CITY OF ALBUQUERQUE

July 27, 2021

**Re: Facility for Apple Canyon Gourmet
1301 Cuesta Abajo Ct NE
Traffic Circulation Layout
Architect's Stamp 07-08-2021 (D16-D002H)**

EXHIBIT "C"

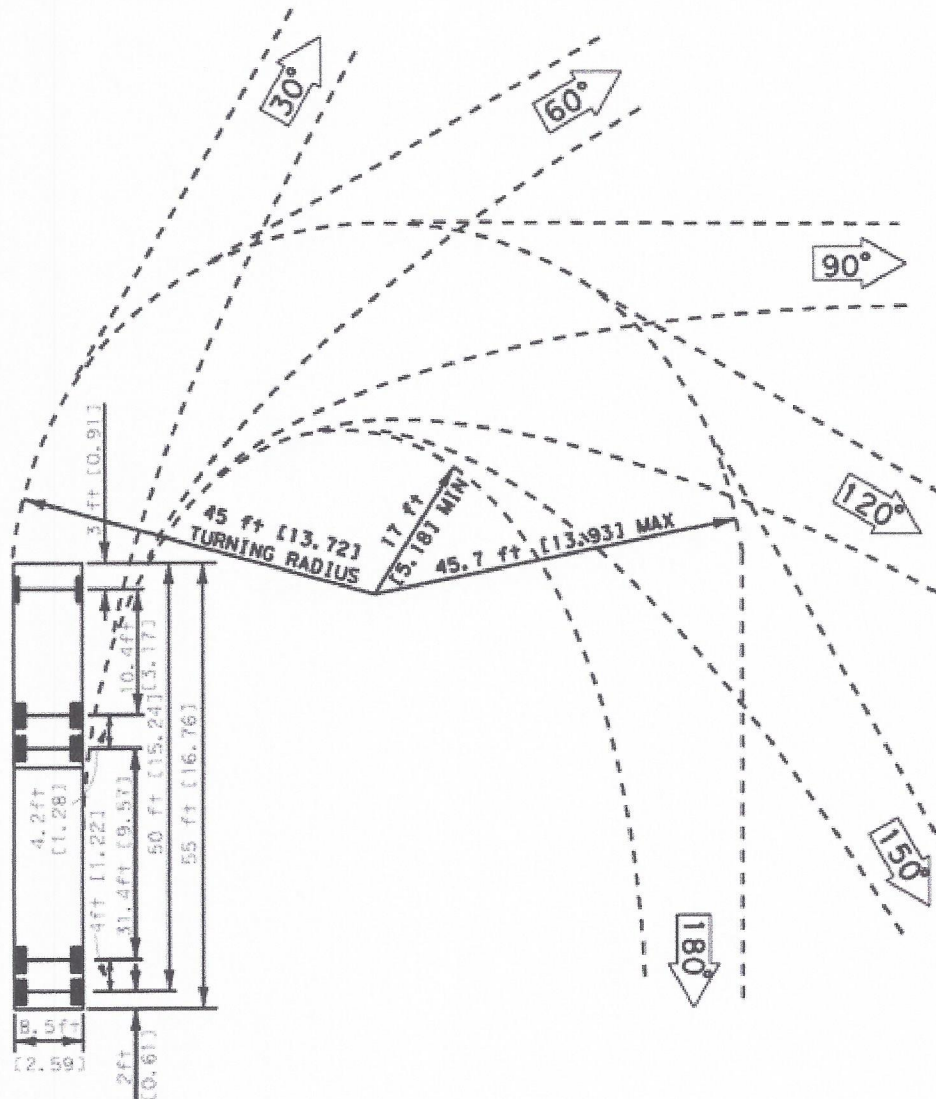
1. Listed are the number of parking spaces required by the IDO as well as the proposed number of parking spaces including bicycle and motorcycle parking.
Coordinate/discuss with Zoning.
2. **Provide turning template exhibit for your delivery vehicles shown on site plan for ingress/egress movements at entrance.**
3. Identify all existing access easements and rights of way width dimensions **(IF APPLICABLE)**.
4. **Provide all street names for proposed development. Some names are no shown on site plan.**
5. **Provide notes on site development infrastructure for proposed versus existing.**
6. Identify the right of way width, medians, curb cuts, and street widths on Las Lomitas and Cuesta Abajo Ct.
7. **The minimum parking stall dimensions are:**

EXHIBIT "E"

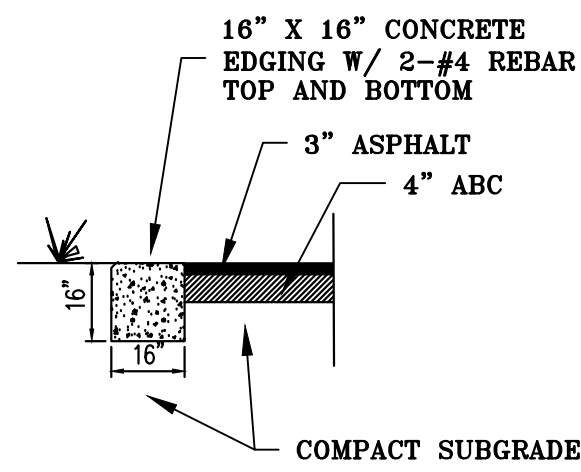
20. **Provide a copy of refuse approval.**
21. **It is not apparent what type of pavement surface is being proposed. A hard driving surface will be required as part of this proposed project for parking area and drive aisles. Provide design for truck/delivery route.**

B.2 BIKE RACK
NO SCALE

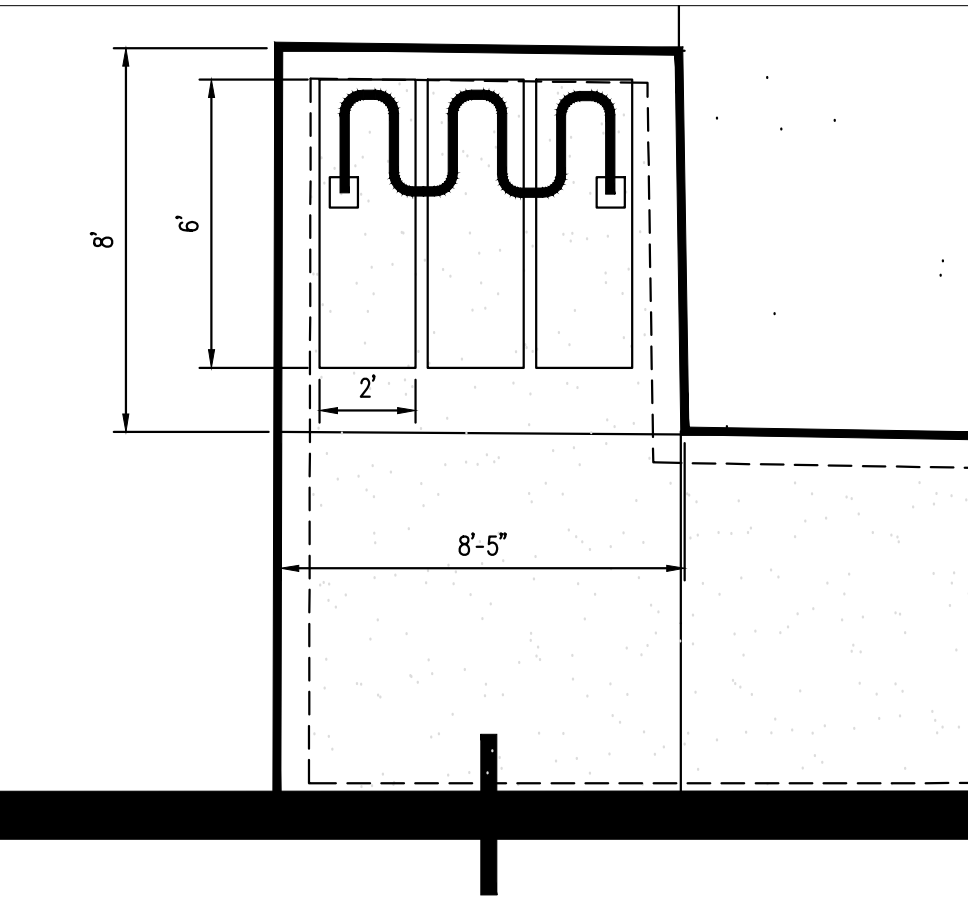
10. Motorcycle parking space: **Label pavement MC.**
11. **All bicycle racks shall be designed according to the following guidelines:**
 - a. **The rack shall be a minimum 30 inches tall and 18 inches wide.**

- b. **The bicycle frame shall be supported horizontally at two or more places. Comb/toaster racks are not allowed.**
 - c. **The rack shall be designed to support the bicycle in an upright position. See the IDO for additional information.**

- d. **The rack allows varying bicycle frame sizes and styles to be attached.**
 - e. **The user is not required to lift the bicycle onto the bicycle rack.**

- f. **Each bicycle parking space is accessible without moving another bicycle.**
12. **Bicycle racks shall be sturdy and anchored to a concrete pad.**

13. **A 1-foot clear zone around the bicycle parking stall shall be provided.**
14. **Bicycle parking spaces shall be at least 6 feet long and 2 feet wide.**

SHEET NO.
ARCH 002

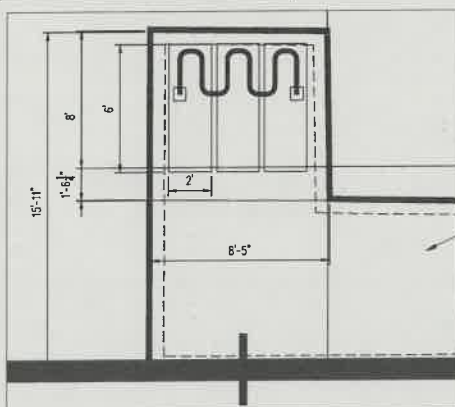
19. **Las Lomas Drive Sidewalk:** A certain northern portion of sidewalk is missing. Coordinate with agency on the railroad tracks to complete the sidewalk connection.
